Appeal Decision

Appeal Ref: APP/Z4718/D/20/3246414

12 Chapel Street, Scapegoat Hill, Huddersfield HD7 4NX

- The appeal is made under section 78 of the Town and Country Planning Act 1990 against a refusal to grant planning permission.
 - The appeal is made by Mr Dean Stephenson against the decision of Kirklees Metropolitan Borough Council.
 - The application Ref 2019/62/93449/W, dated 22 October 2019, was refused by notice dated 10 January 2020.
 - The development proposed is 1st floor extension over existing ground floor extension.
-

Planning
Proposed Plans and Elevations

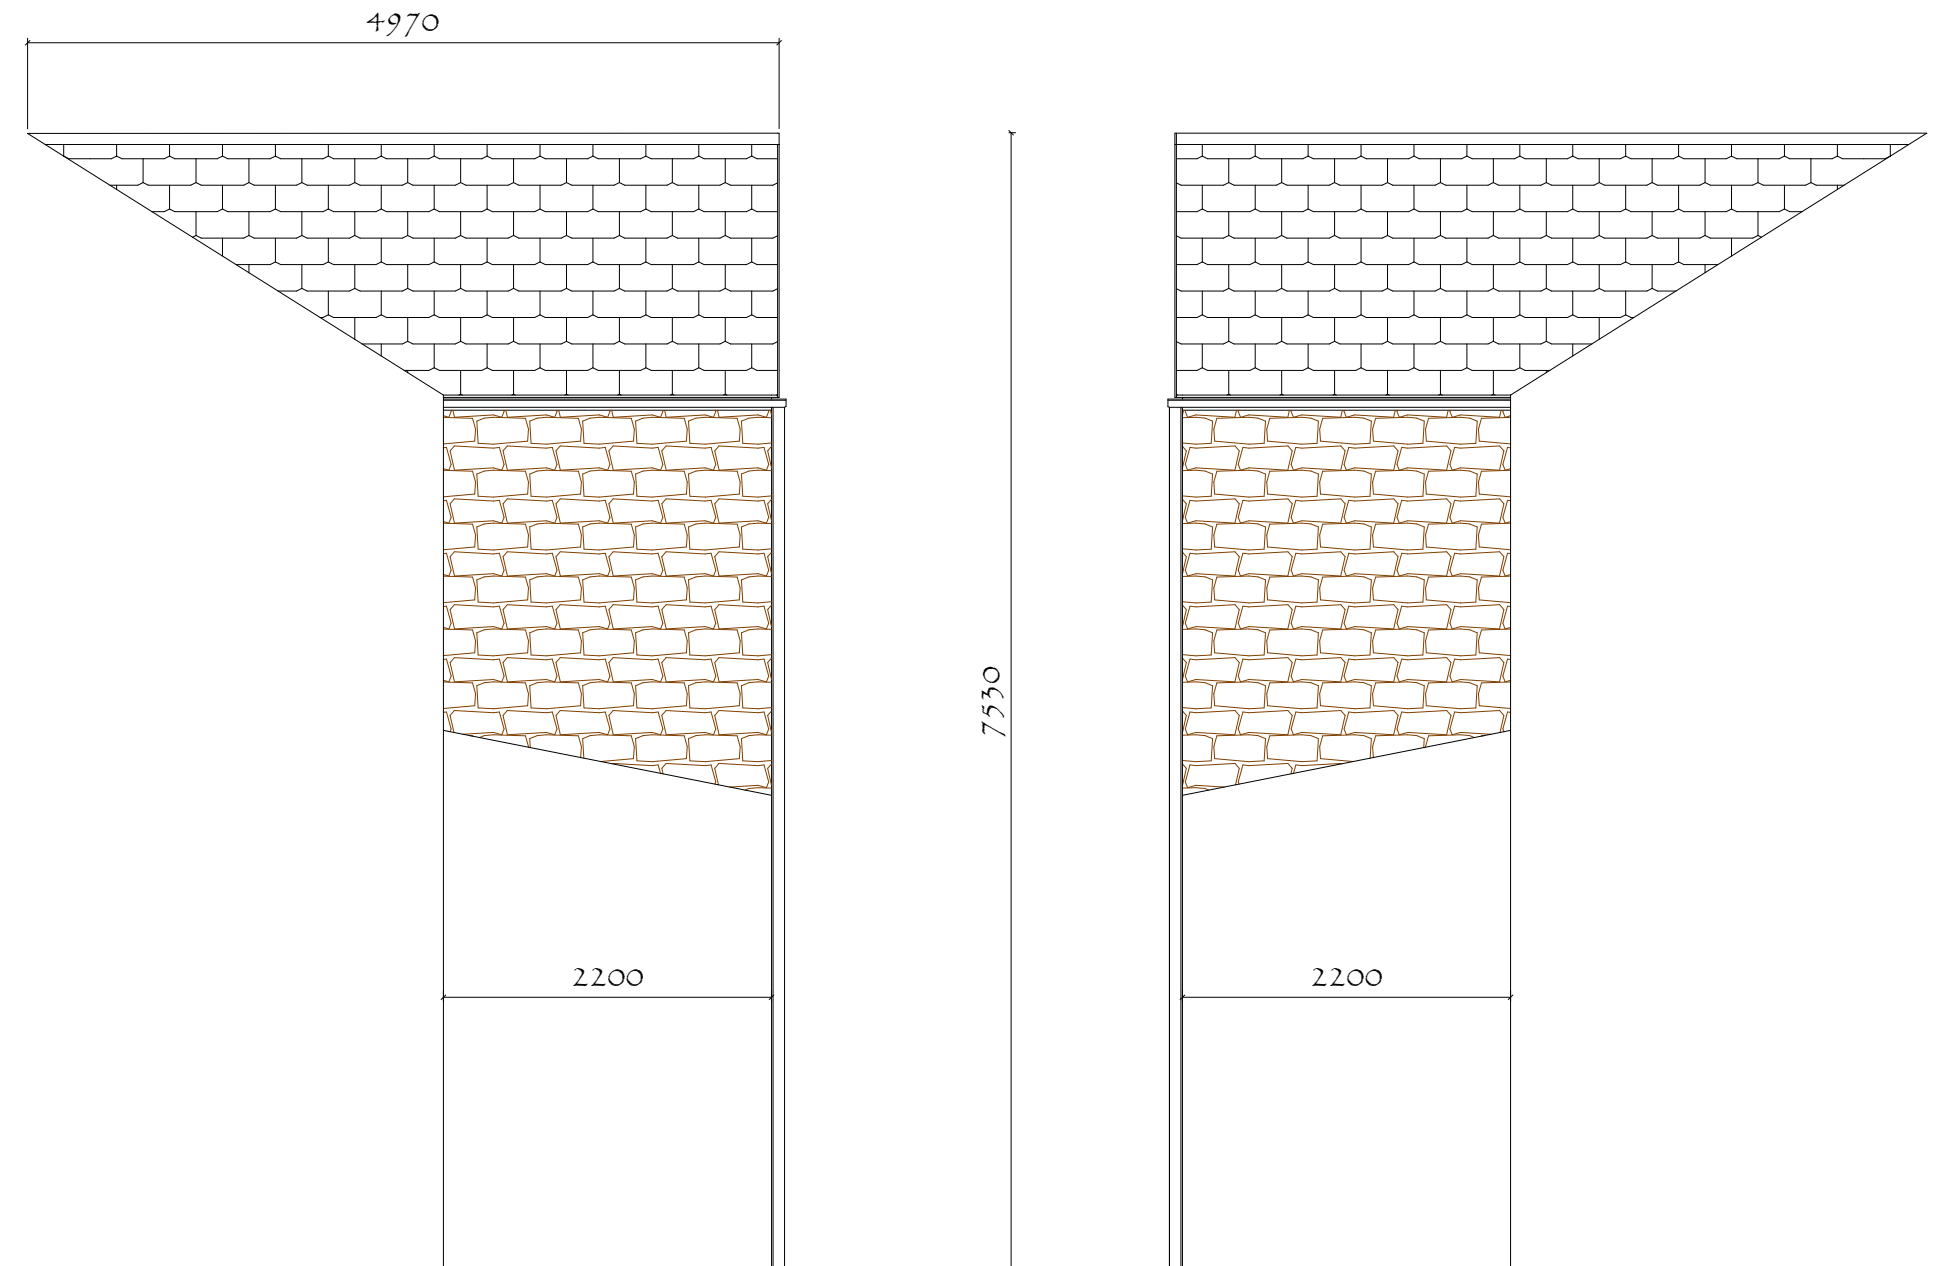
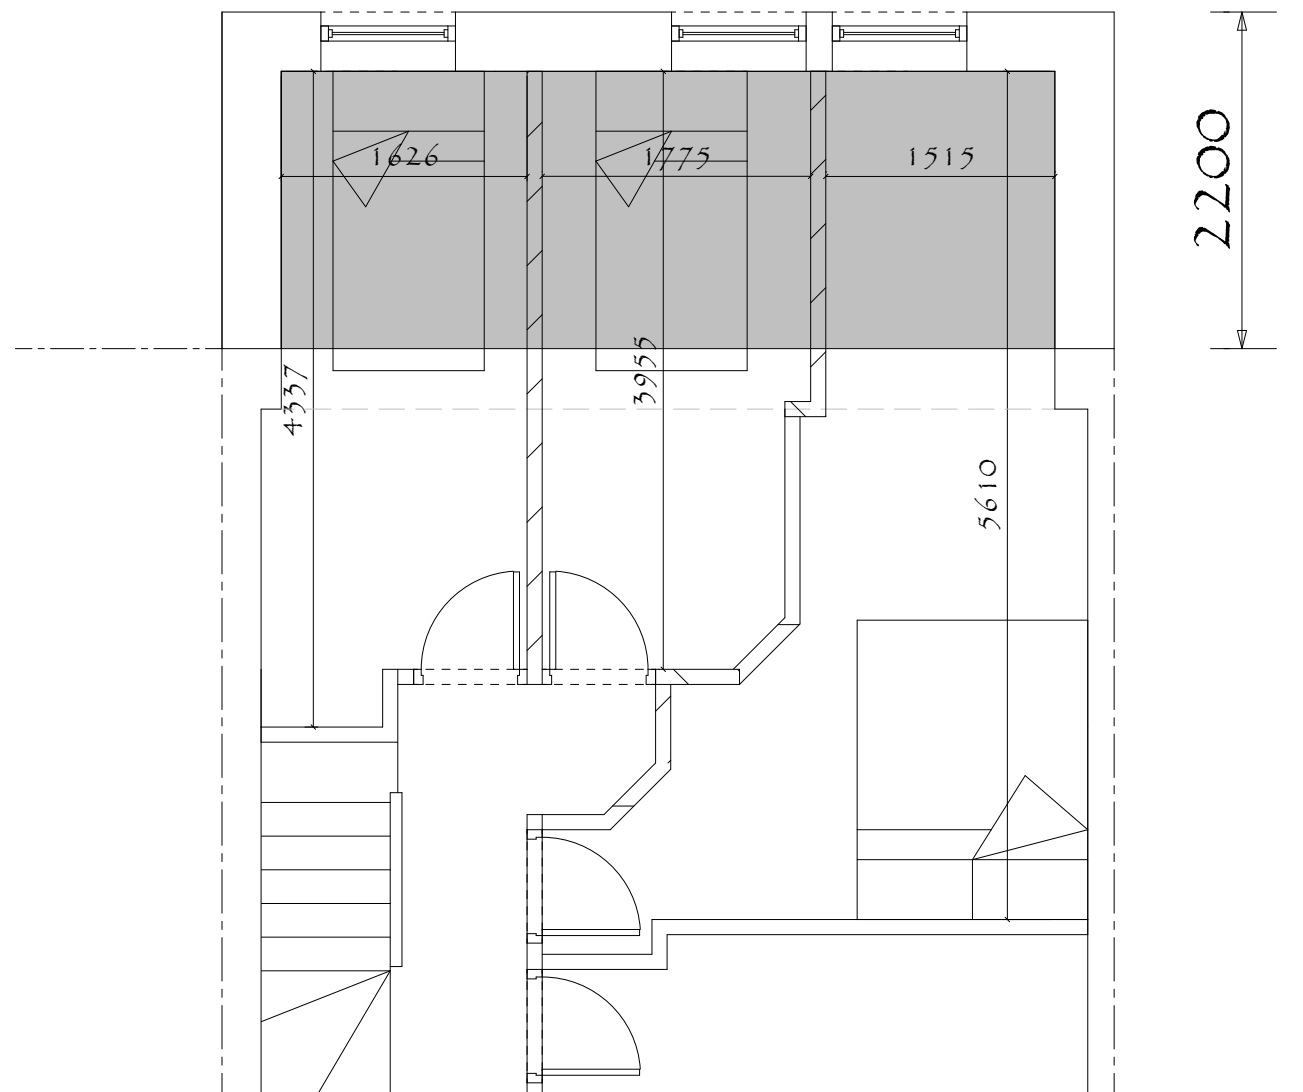
6. The existing extension has a simple lean-to form, and because of its single storey scale reads as a subservient addition to the property and allows the form of the original building to be read. In contrast, the proposal would introduce significant bulk and massing at first floor level which would obscure the form of the existing building and disrupt the linear form of the terrace as a

whole. In addition, the substantial front gable would be an assertive feature at odds with the simple character of the existing building. As a result, the extension would appear as a dominant and discordant feature on this side of the terrace. It would be particularly prominent when viewed from School Road, and whilst I have noted the presence of garages and outbuildings in front of the terrace these are single storey buildings that would not obscure the proposed development.
